Ballpark Dr. Subdivision

July 20, 2004

RE: Proposed Ballpark Drive Subdivision  
ID #2004-0028, CBL #371 A002001

SHEET TITLE:	PLAN OF DIVISION OF LAND THE HAVERTY ESTATE PROPERTY BALLPARK DRIVE SUBDIVISION	SHEET 1 OF 10
SCALE:	1" = 100'	DATE: SEPTEMBER 3, 2004
		DRAWING NO.: 1

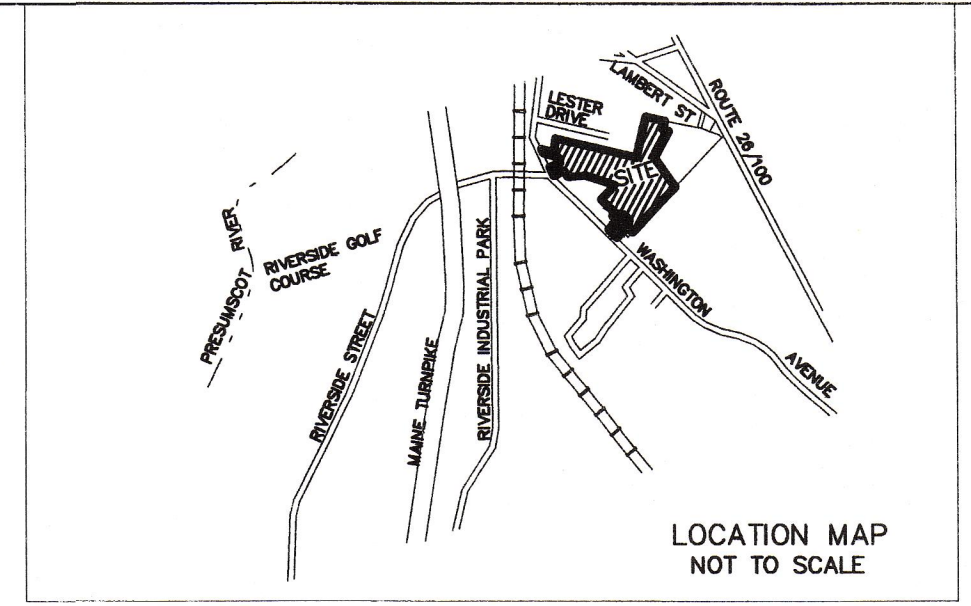
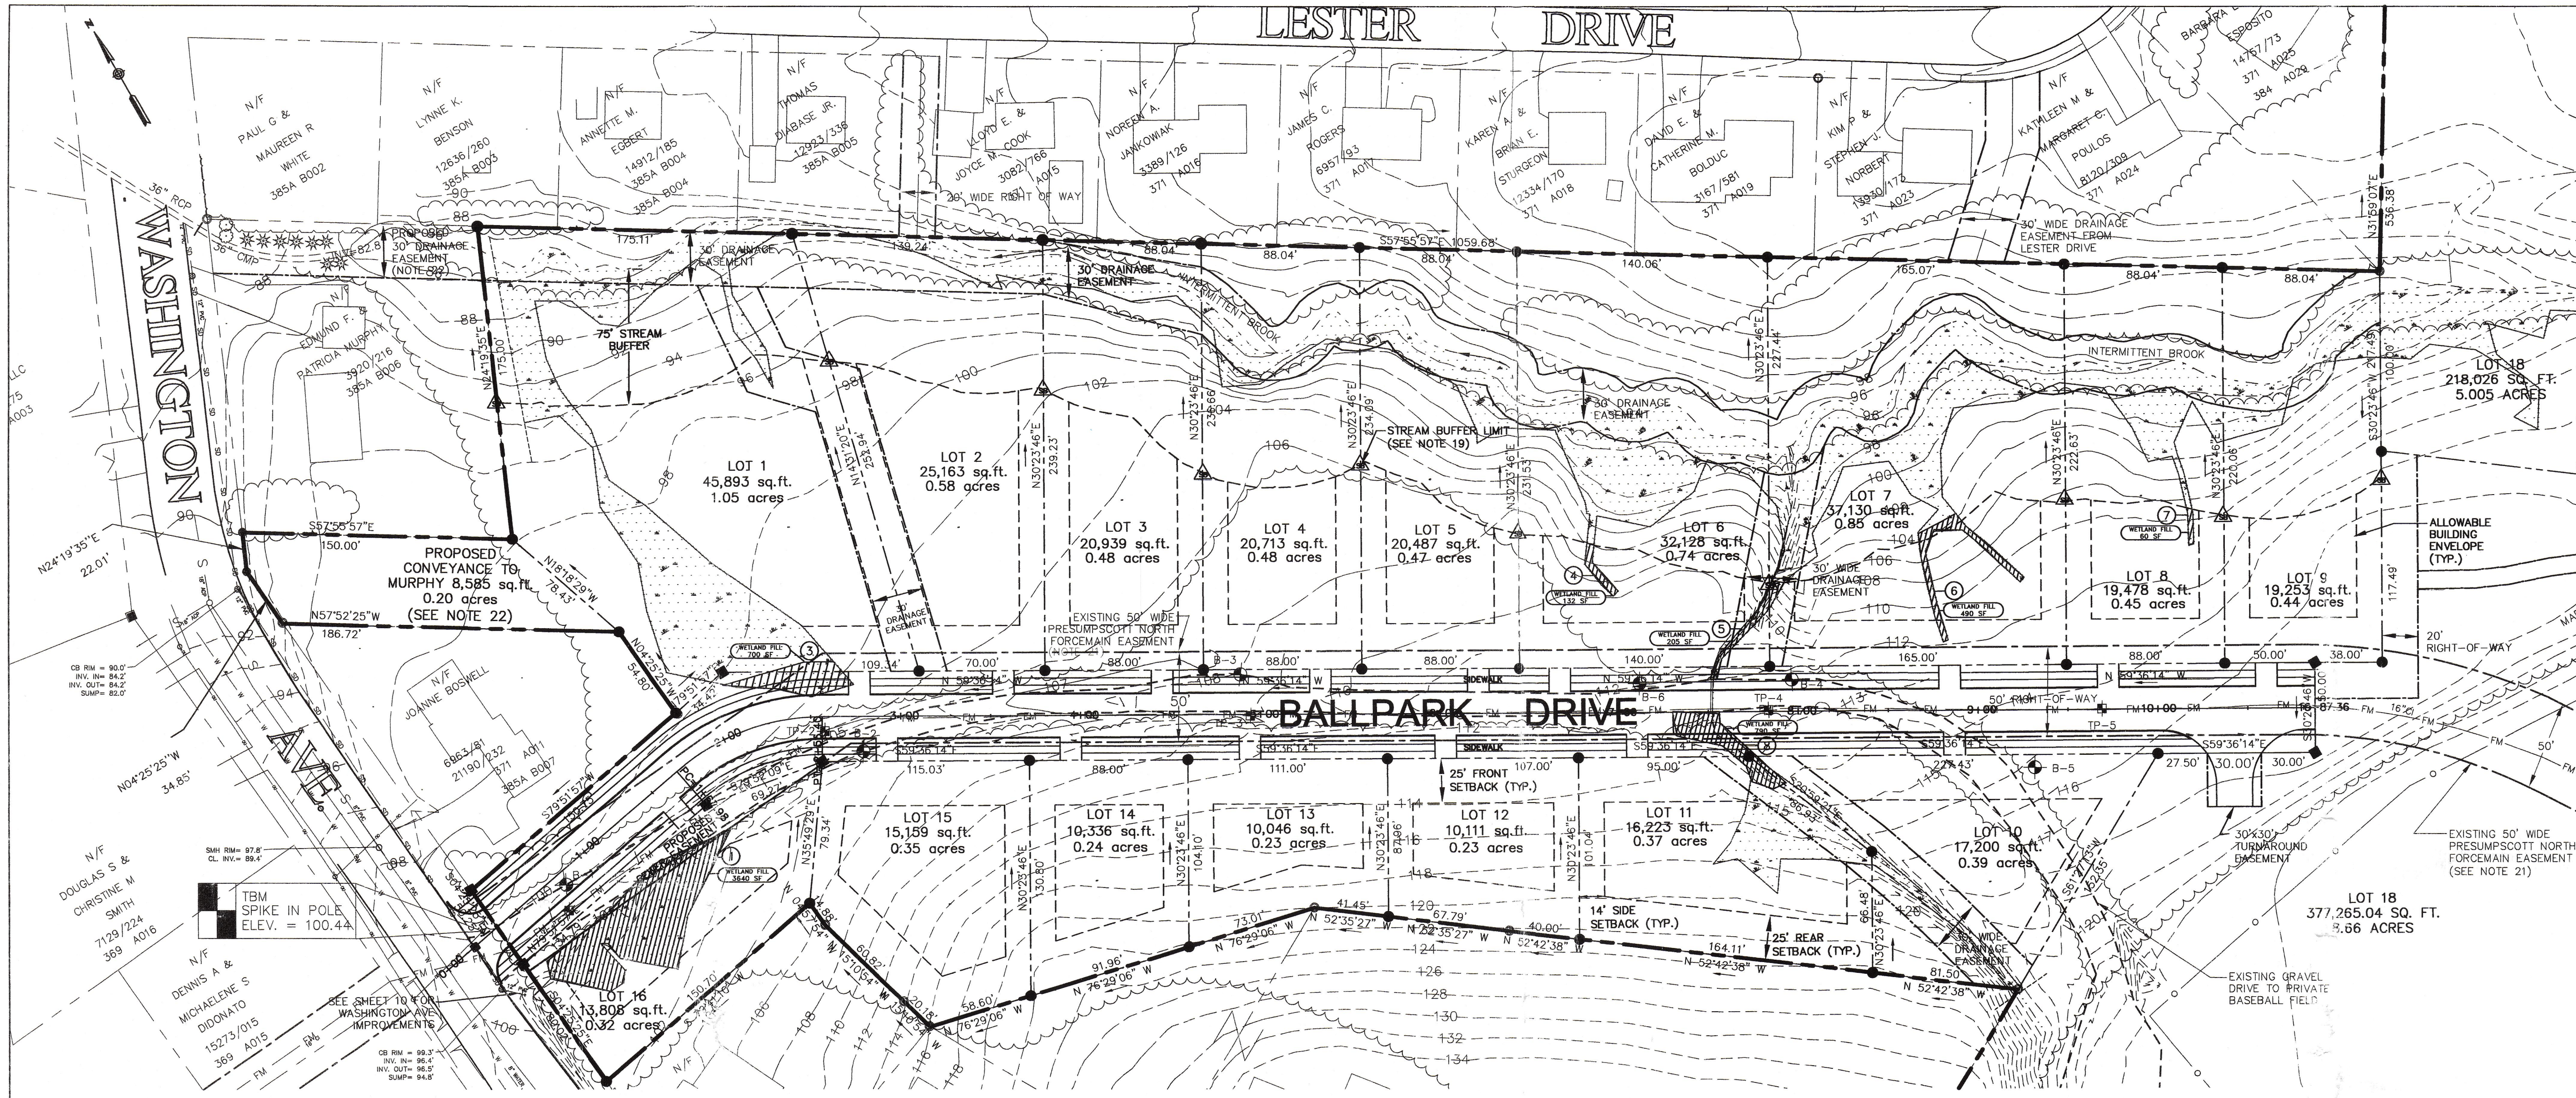
- ii. The applicant shall remove from the plans the 10 foot wide trail easement shown across lot 17 and replace it on the plans with a 20-foot wide trail easement which shall link the Ballpark Drive right of way with the Grace Baptist Church property across lot 18 so as to facilitate an eventual through connection to Lambert Street in coordination with Portland Trails and subject to review and approval by the Planning Authority.

viii. Lot 18 as shown on sheet 1 of the plan set dated September 3, 2004 shall be conserved in perpetuity by deed restriction, conveyance to an approved land trust, or by other legal mechanism subject to final review and approval by Corporation Counsel.

ix. The applicant shall submit revised plans with a 50 foot wide panhandle added to lot 18 so as to provide that lot with its required 50 feet of street frontage onto Ballpark Drive.
